CITY OF ALBUQUERQUE

July 29, 2025

RE: High Mesa Trail Phase 2
99999 Arroyo Vista Blvd NW
Grading & Drainage Plan
Engineer's Stamp Date: no stamp / date
Hydrology File: J07D002
Case # HYDR-2025-00265

DESIGNED BY JL DATE XXXXXXXX
CHECKED BY JL DATE XXXXXXXX
DRAWN BY DO DATE XXXXXXXX

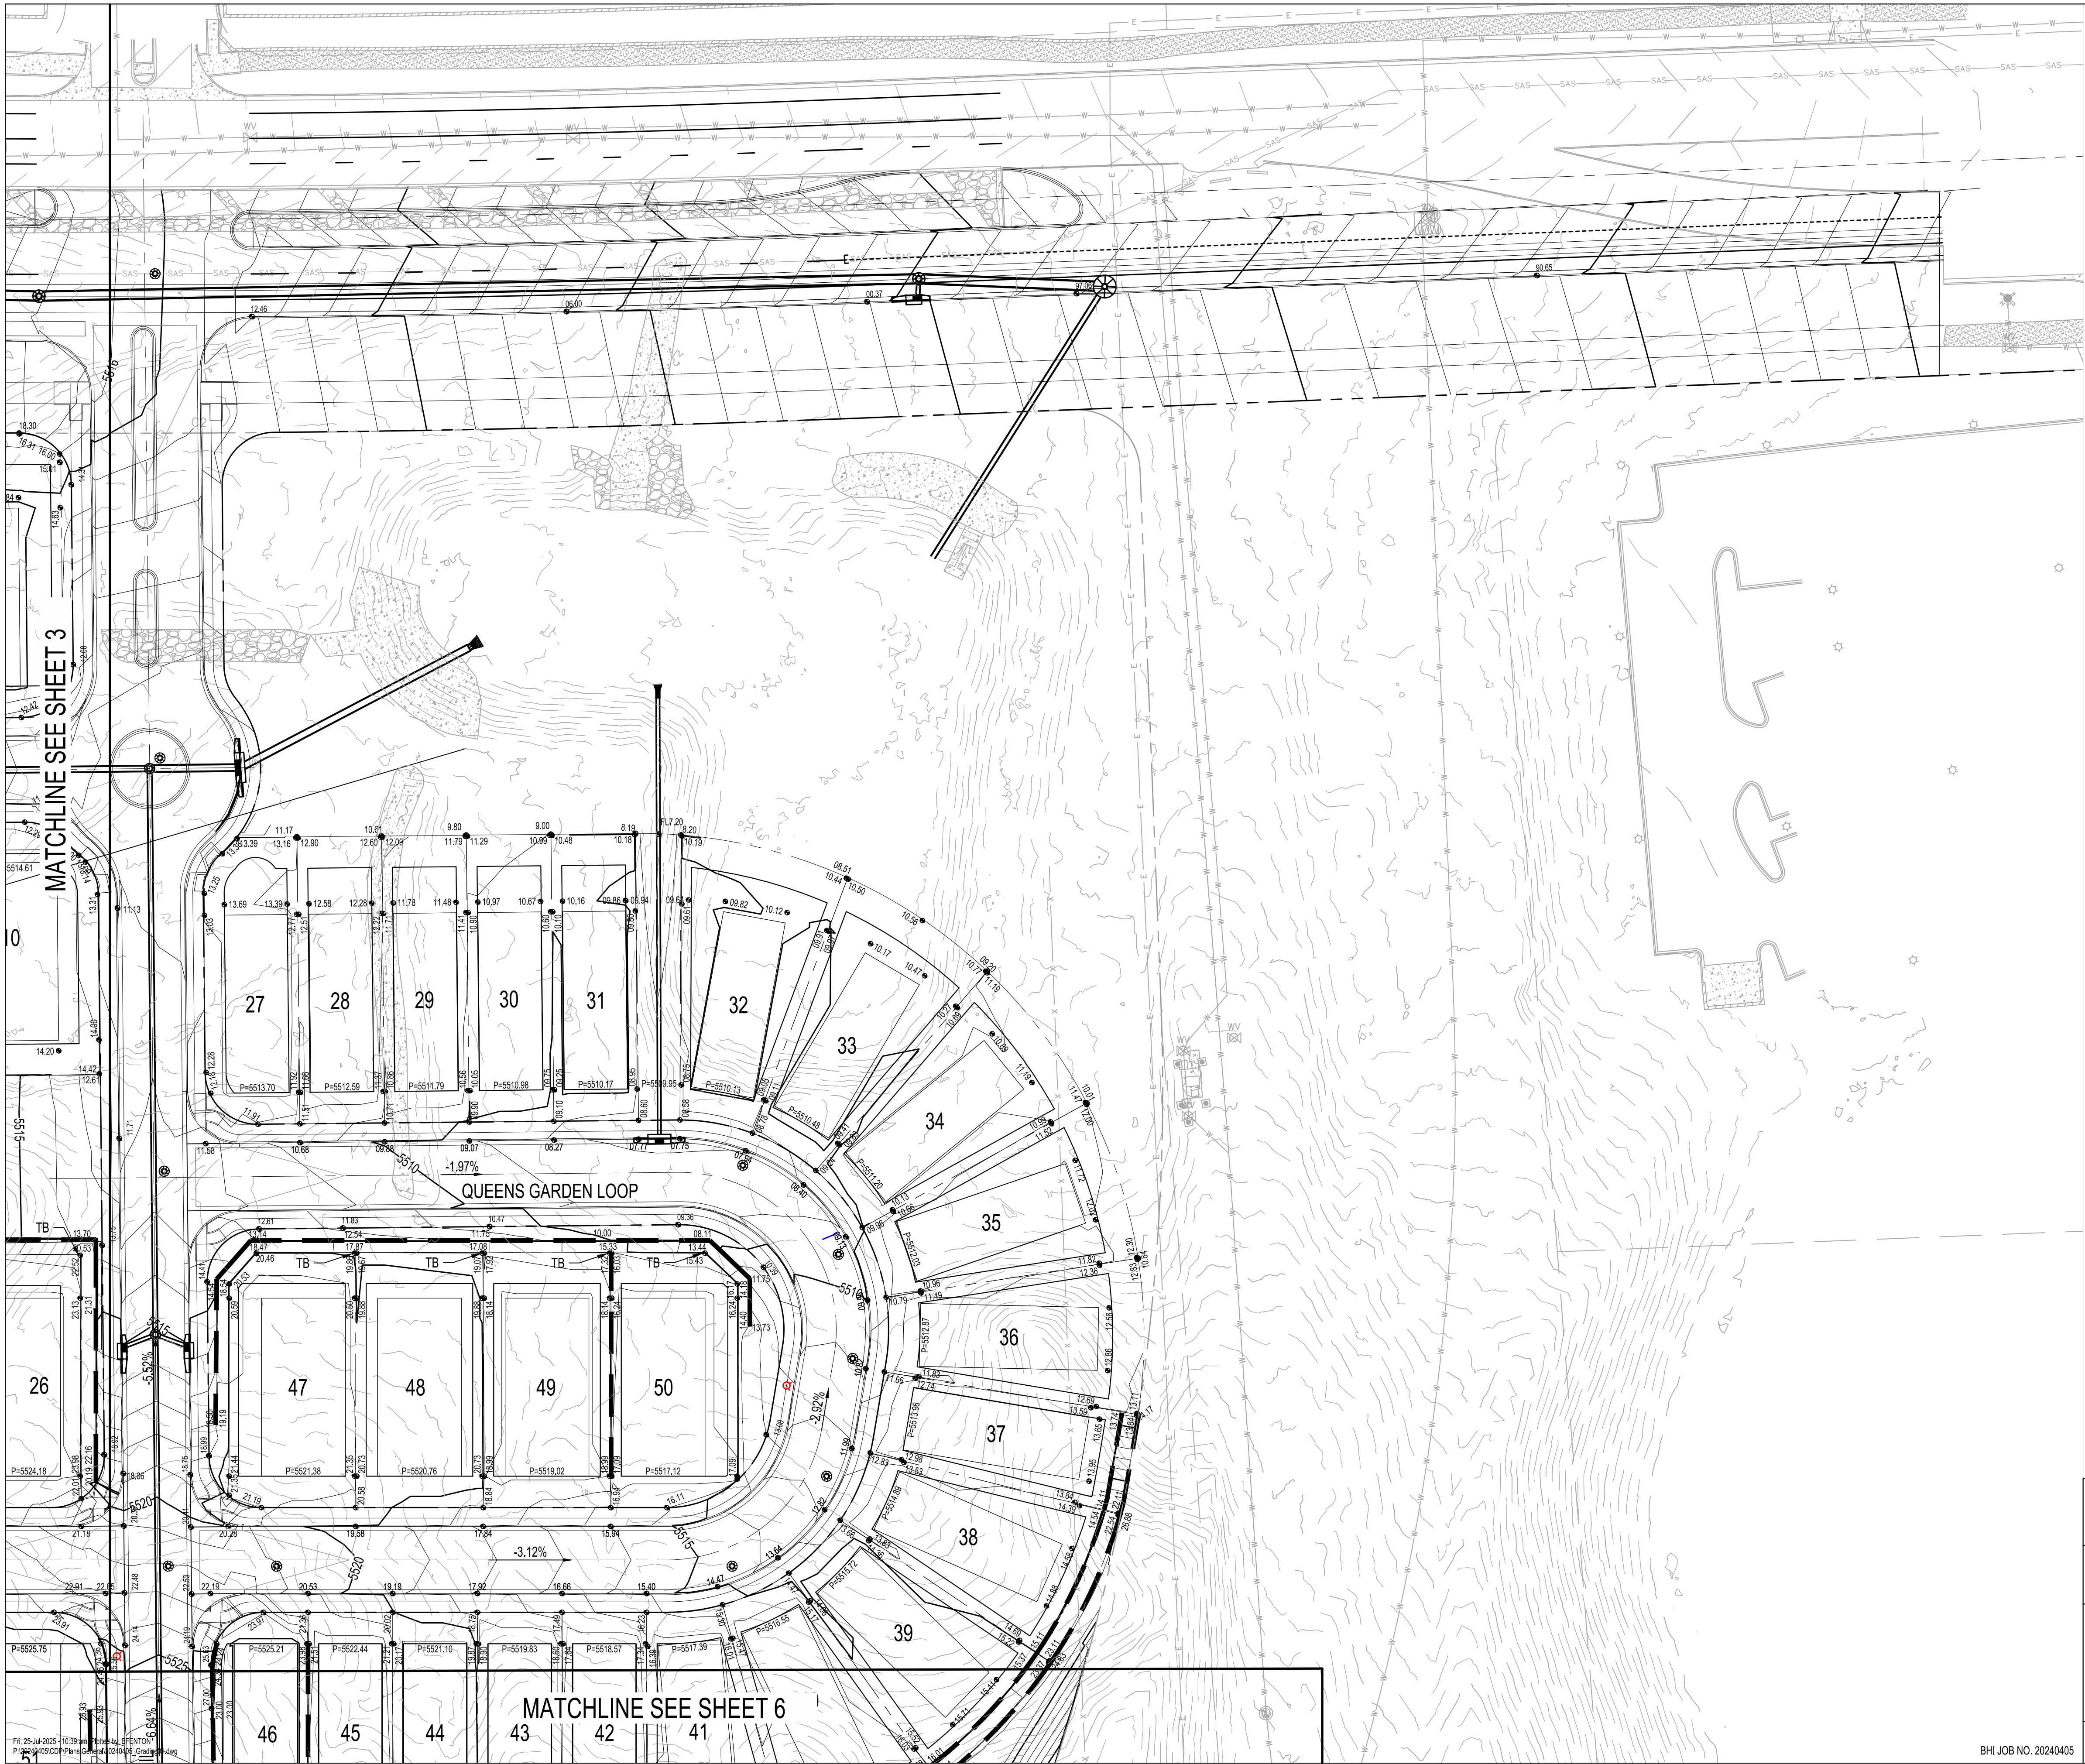
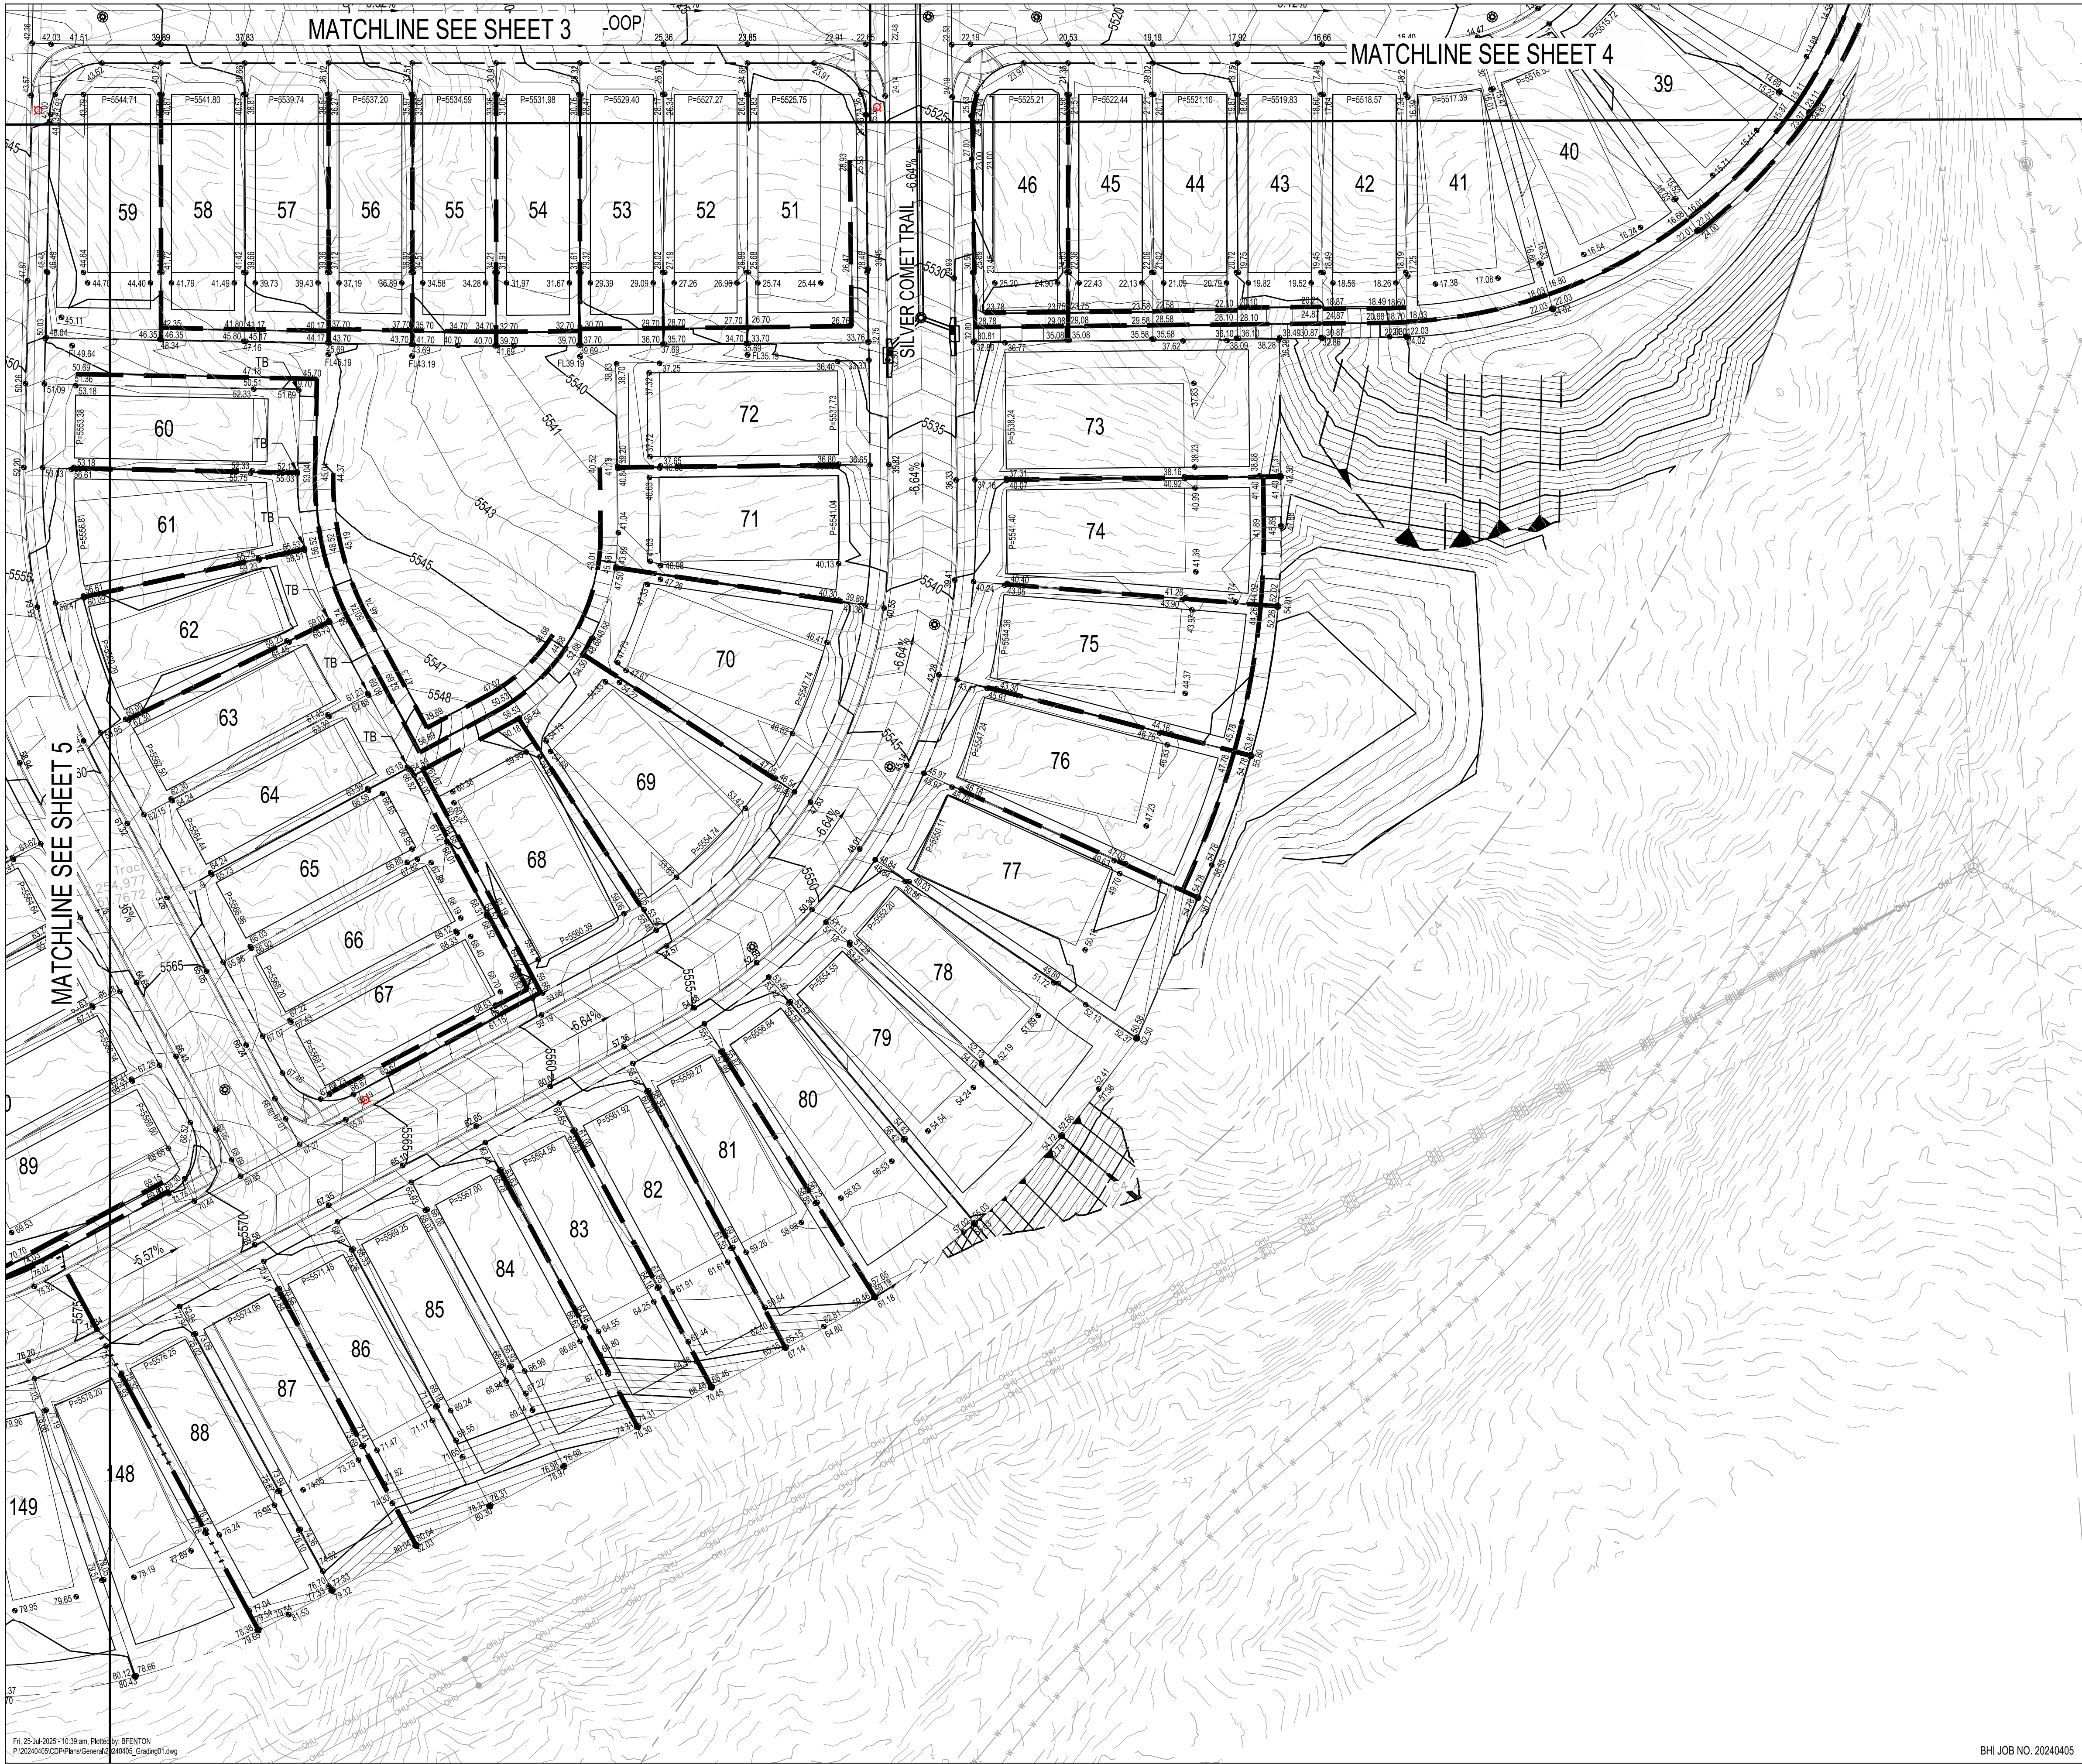
1. Per the IDO, the property owner of the property is responsible for building the adjacent half of Arroyo Vista Blvd. NW to include curb & gutter, and sidewalk. The project will have to go to the Development Facilitation Team (DFT) for approval of the Infrastructure List.
2. If only seeking approval of the Infrastructure List at this time, label the grading plan "Conceptual, Not For Construction" or similar and address all comments.
